From: Vanessa Aziz <vaziz@cityofsydney.nsw.gov.au>
Sent: Tuesday, 12 February 2019 3:23 PM
To: Tim Green
Subject: Modification Request for Barangaroo South Basement - Stage 1B (SSD 6960 MOD 1)

This section 4.55(1A) application (SSD 6960 MOD 1) relates to the following changes to the layout of the approved Basement, comprising:

**STAGE 1B BASEMENT SSD6960  
BASEMENT PLAN LEVEL B1**

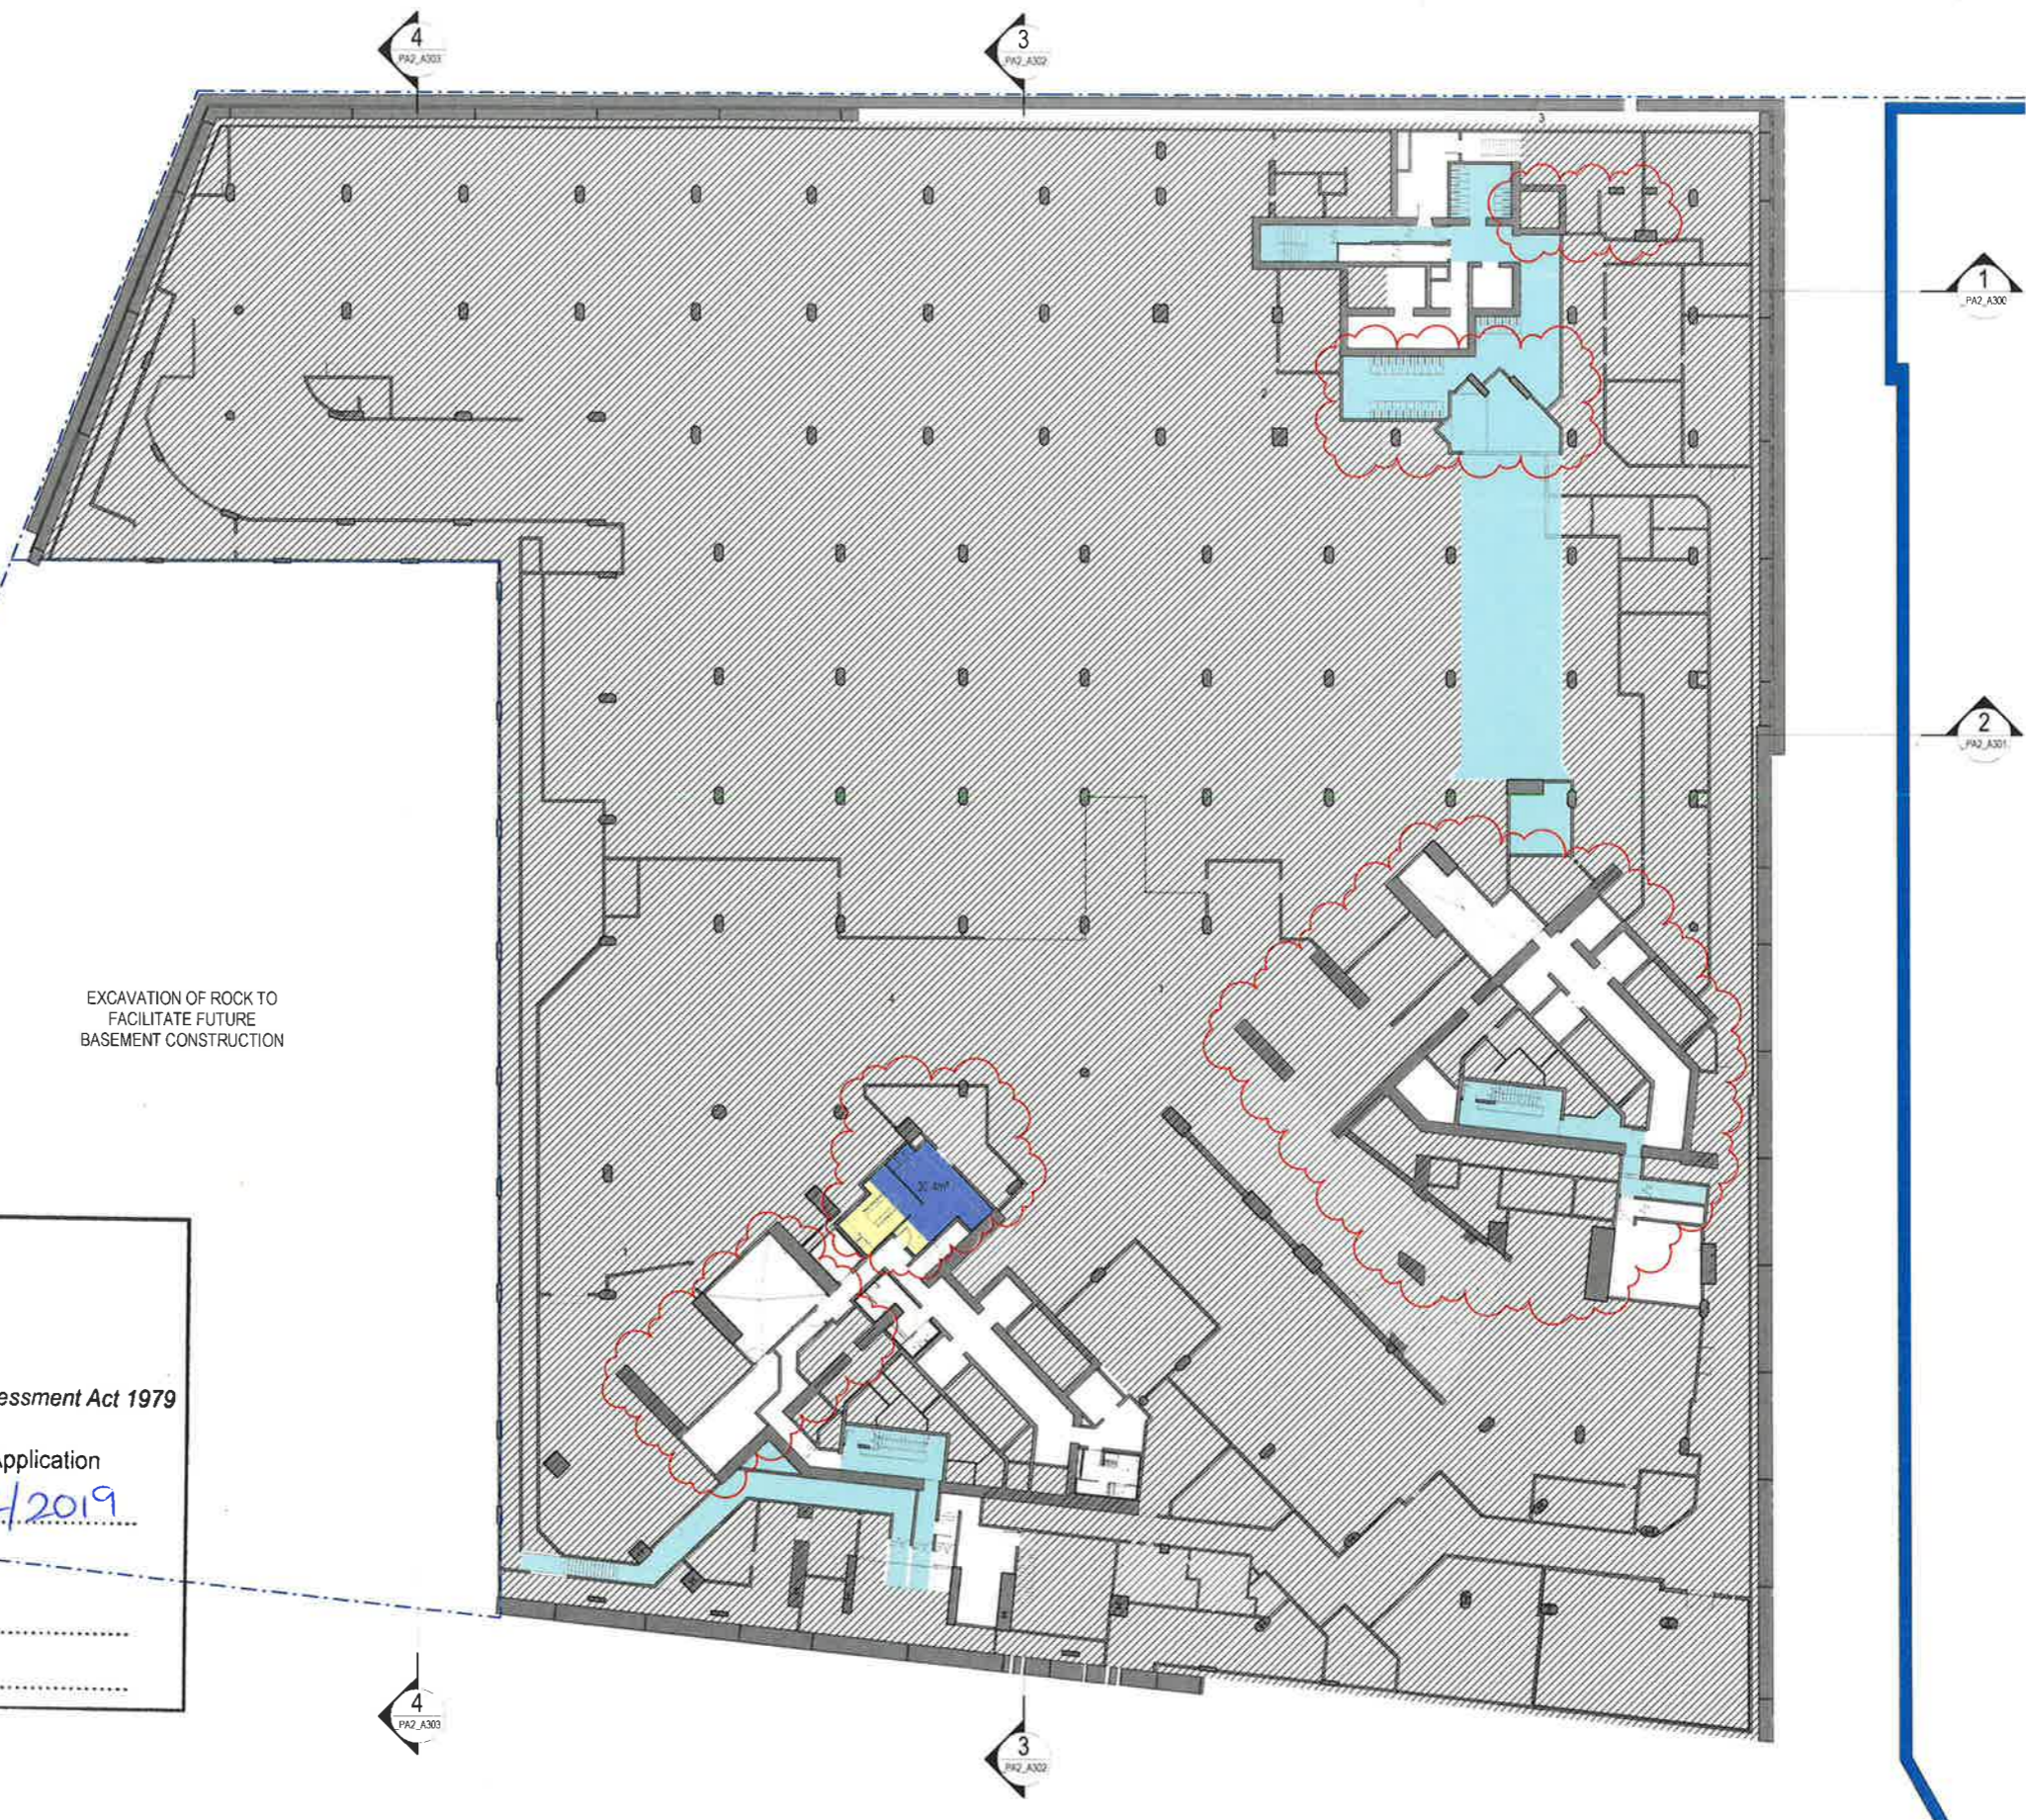
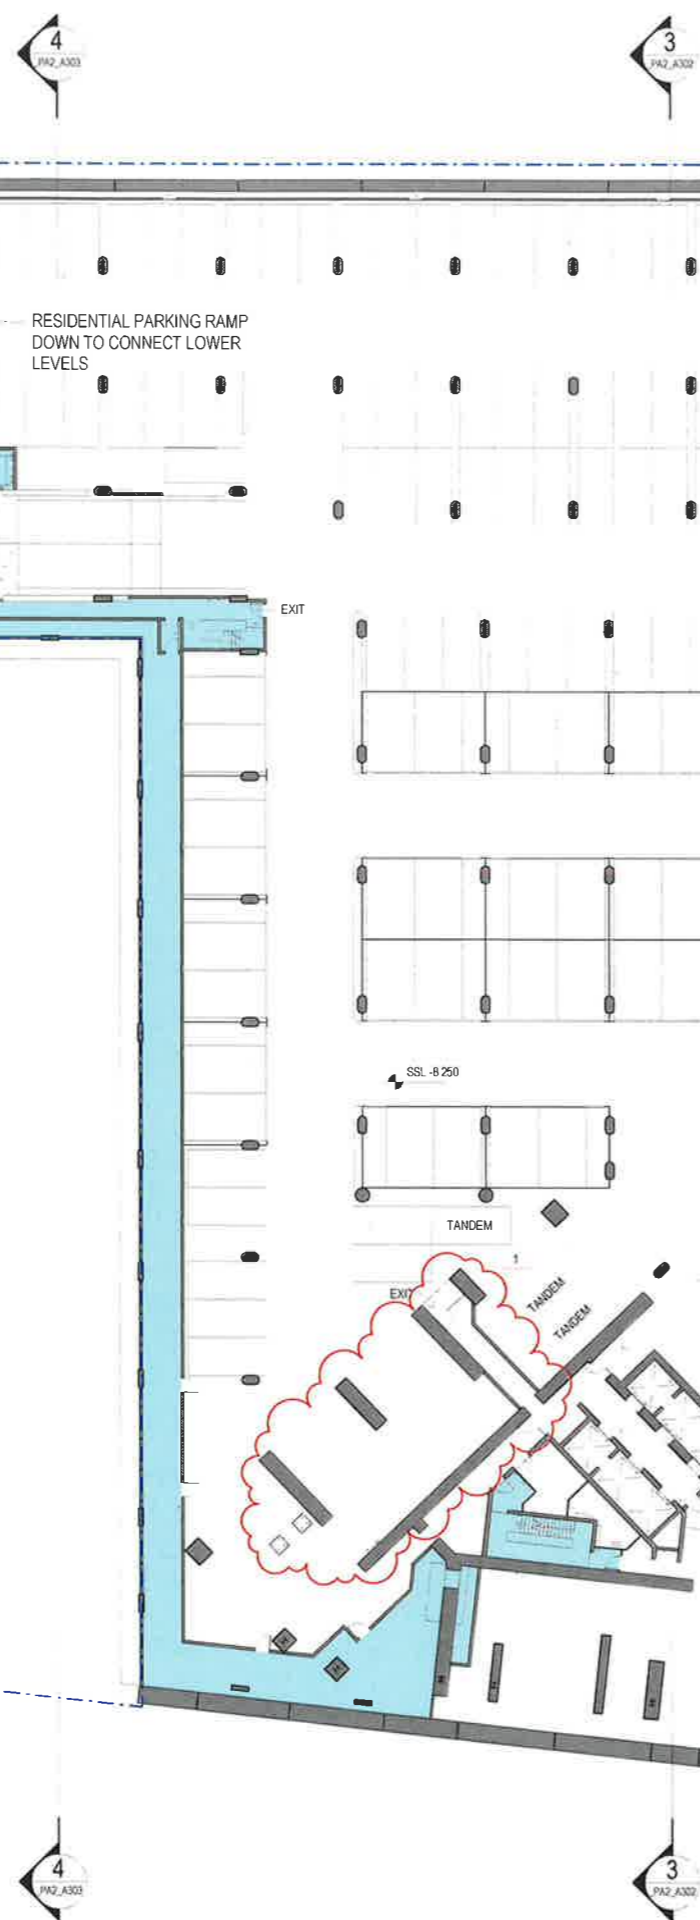
The modified plans show that the parking capacity of the basement has been modified to allow for a greater number of car parking spaces which appears to have been calculated against the Sydney Local Environmental Plan 2005 (LEP 2005). It is premature to assume that an increase in car parking numbers will be supported as part of SSD 6966 for Building R5 which is currently under assessment.

The City reiterates that car parking rates should not be calculated against LEP 2005. In addition, given that Sydney Metro Station at Barangaroo is about to open which is a major upgrade in the public transport system available from the concept phase approval, it is recommended that on-site car parking should be calculated in accordance with the Sydney Local Environmental Plan 2012.
